Application No: M/92/20/HH
Site Address: 67-69 Lych Gate House Elmer Road Middleton-On-Sea PO22 6EH
Description of works: Two storey rear extension and single storey front extension, first floor front extension

Thank you for your internet representation made on 10th January 2021 which has been recorded as an objection with the comments as follows:

Proposed First Floor Plan

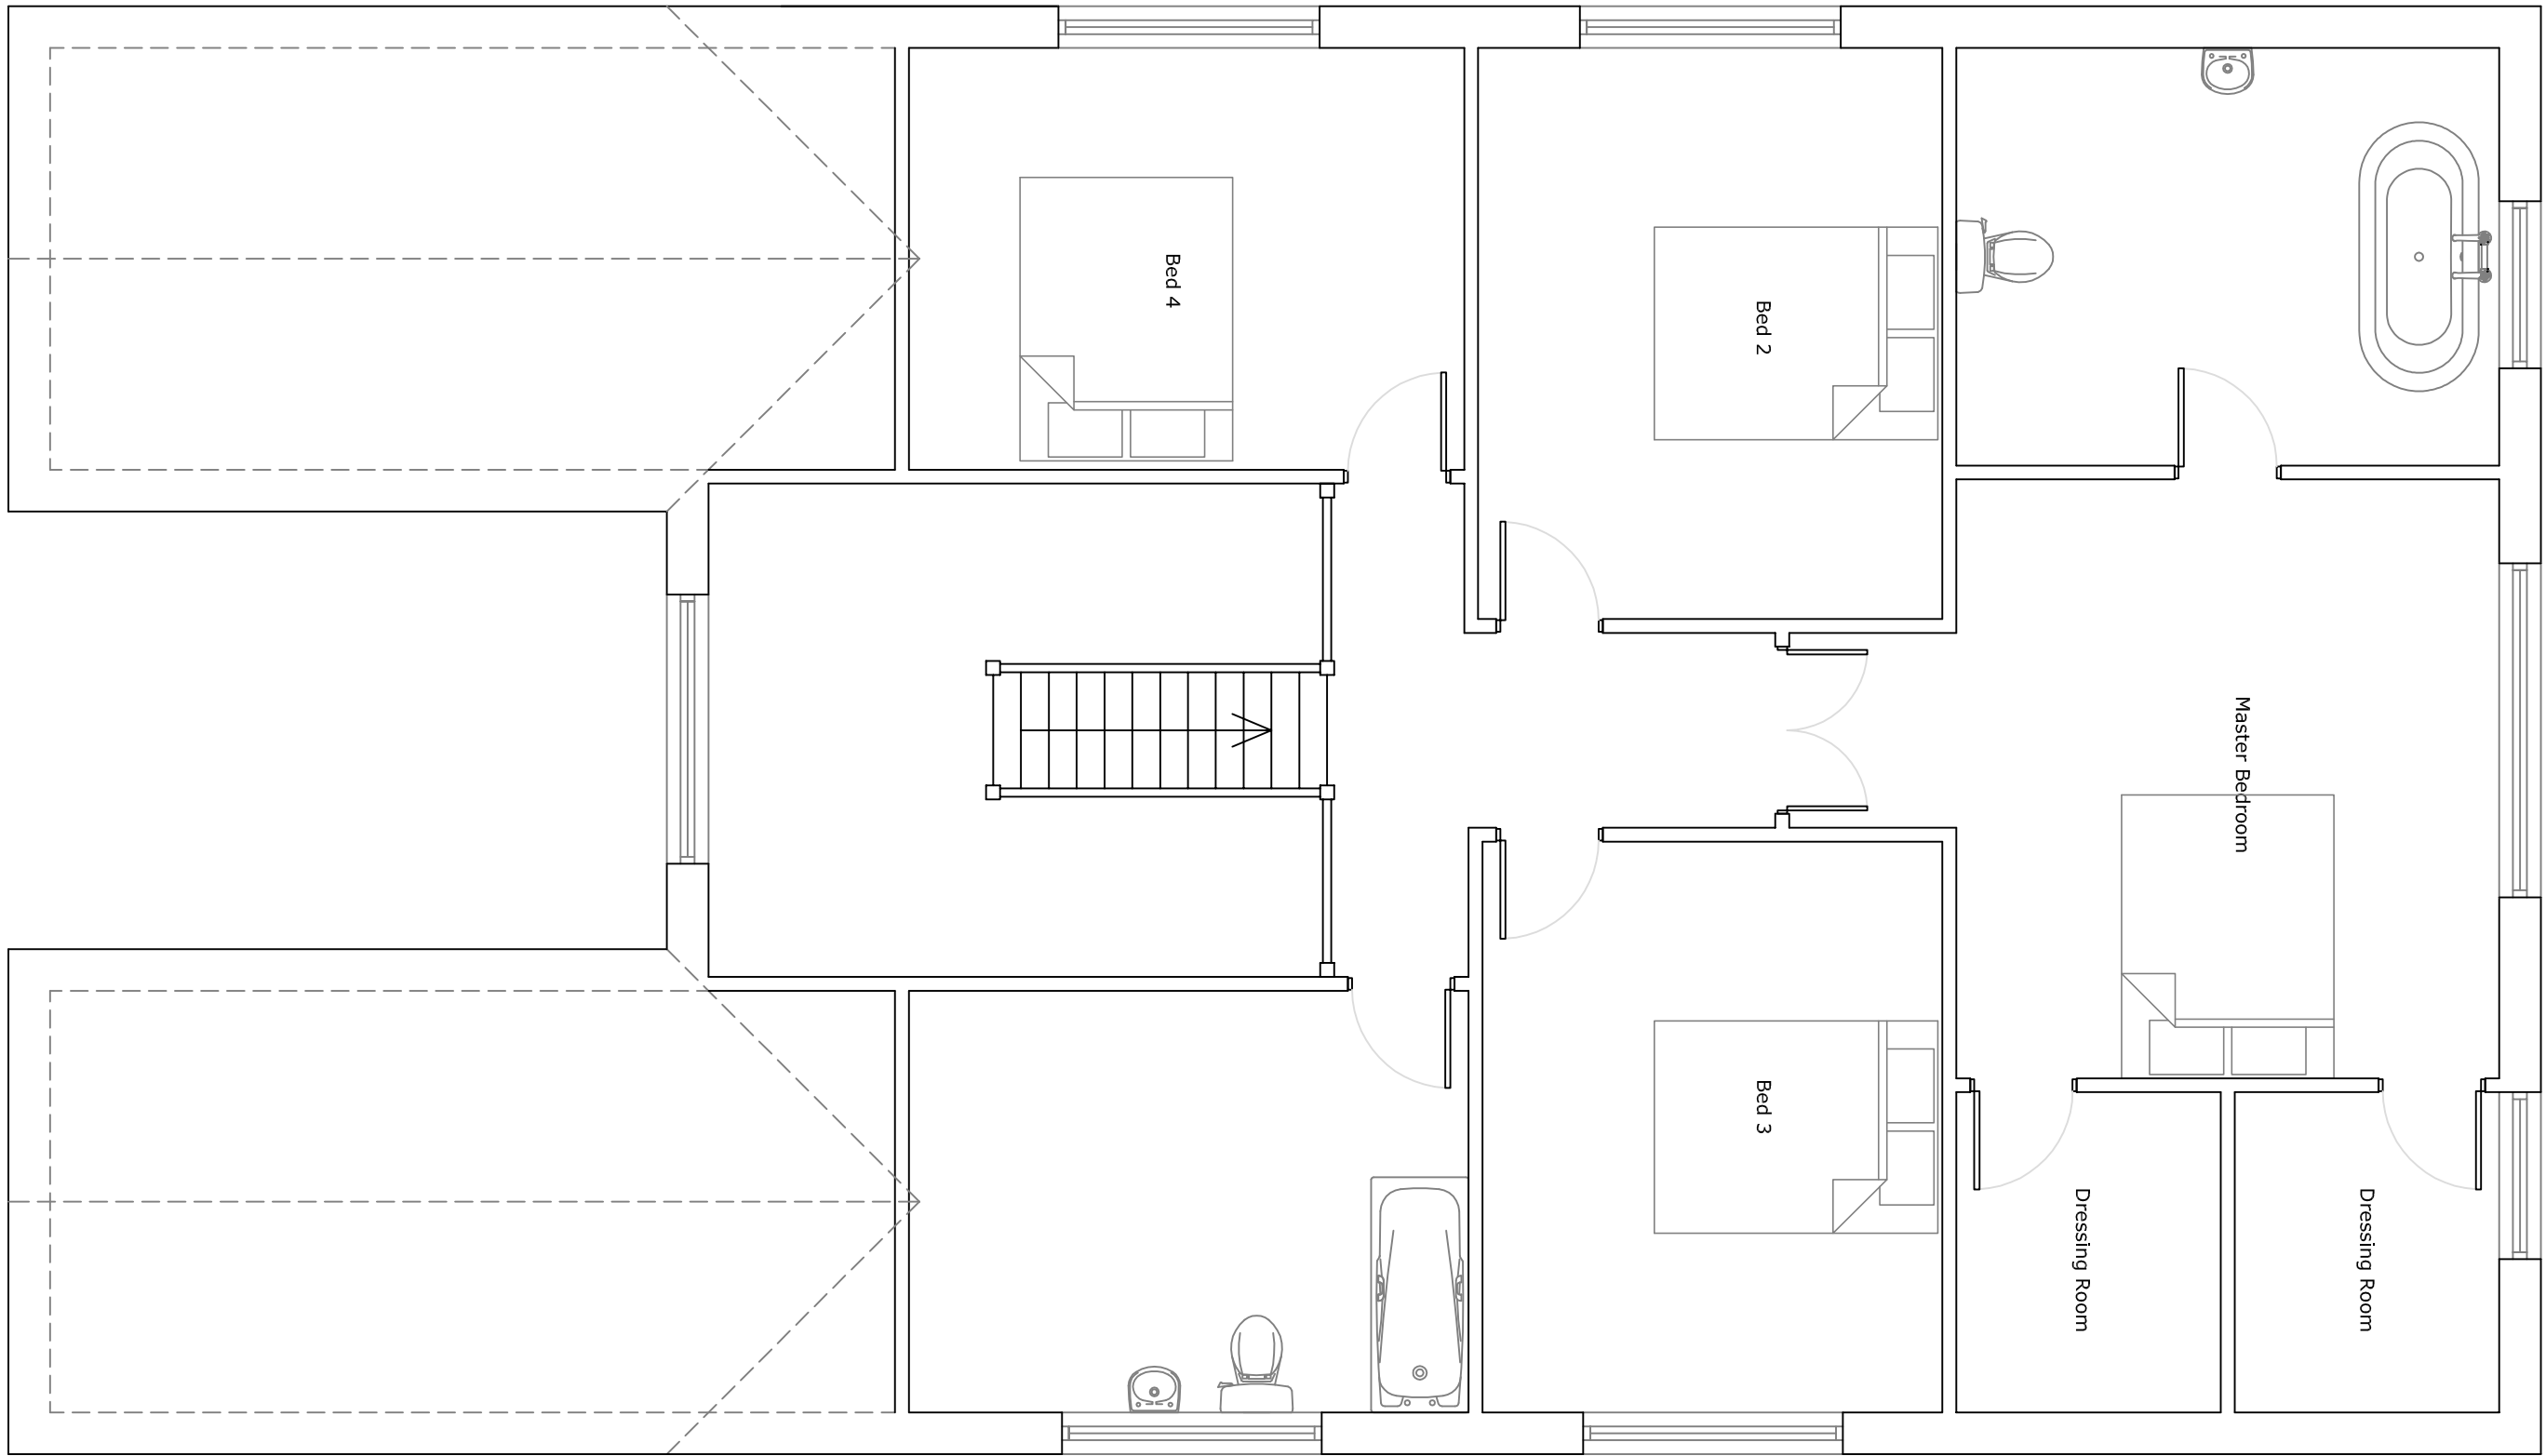
The proposed extension causes us great concern about losing our privacy as it would look straight into our kitchen and main bedroom from the window of bedroom 3 on the new plan. The size of the proposed extension will block evening sunlight from the kitchen, garden and patio of our house.
